**RE: Precision Eye Center
7521 Alameda Blvd. NE
Grading & Drainage Plans
Engineer's Stamp Date: 04/19/23
Hydrology File: C19D070**

Re: C19-D070 Responses to Hydrology Comments received on 3/16/2023

**RE: Precision Eye Center
7521 Alameda Blvd. NE
Grading & Drainage Plans
Engineer's Stamp Date: 02/28/23
Hydrology File: C19D070**

GRADING AND DRAINAGE PLAN

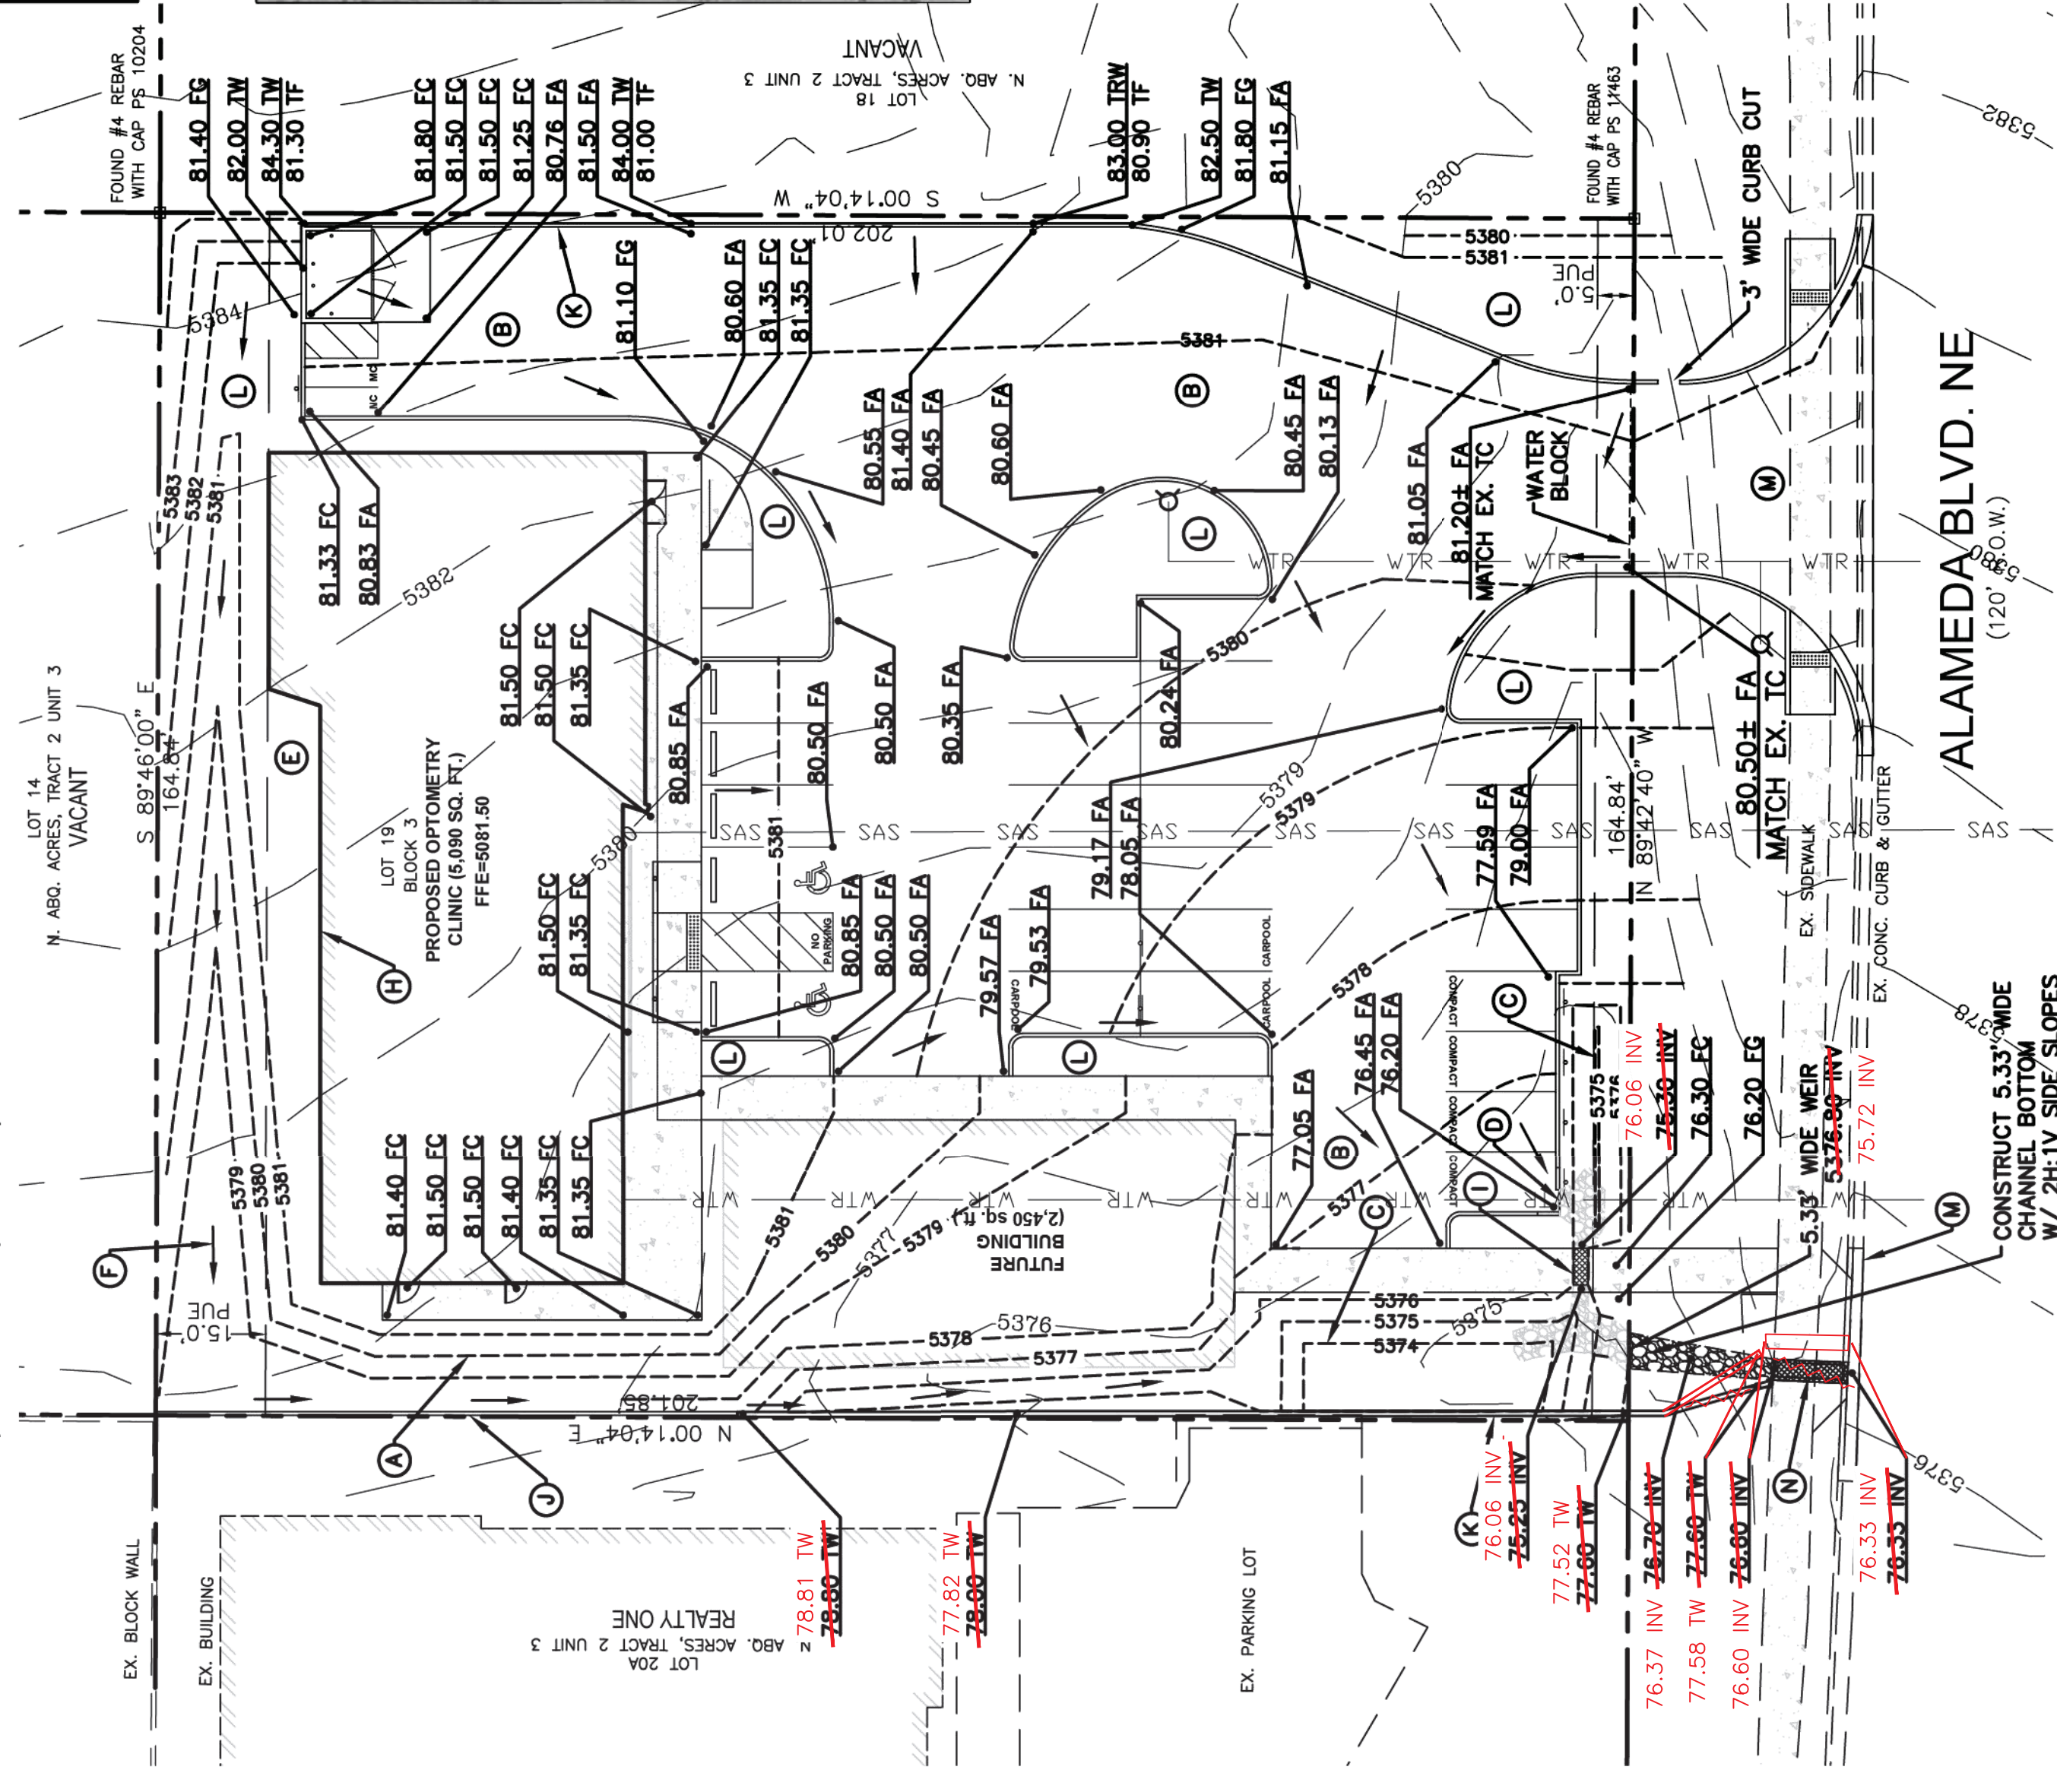
1. Please do not provide Sheets C-001 (Civil Notes), C-101 (Utility Plan), C-301 (Trash Enclosure), and D-101 to D-105 (Civil Details). Hydrology only approves Sheets C-102 (Grading Plan), C-103 (Drainage Plan), and C-201 (Wall Plan & Profile). **relevant details attached**
2. The project curb returns cannot extend beyond the property line. The curb return must become tangent at or before the property line, so please move the entrance about 23 ft to the west. Also, please make the other curb return tangent to the existing curb because it is currently not buildable as shown. **drive pad location adjusted**

3. The existing drive pad at the southwest corner of the property needs to be called out as "Remove existing drive pad and replace with curb & gutter and sidewalk." **work added**

5.
when La Cueva Arroyo was placed in a concrete channel, so when the adjacent lot is developed, it will be discharging into Alameda which is reflected in the above NAA Master Drainage Plan. Therefore, accommodating for this is not needed, but any existing flows can be just handled with a curb cut in the curb return to allow the flows to go into Alameda Blvd. So, the curvet that shown does not need to be installed and the grades for the drive needs to follow CoA Detail 2426 with a water block. **curb cut added**

Site layout was revised by shifting drivepad to address comments from City Hydrology. This shift resulted in reconfiguration of SWQV pond. All relevant details are provided.
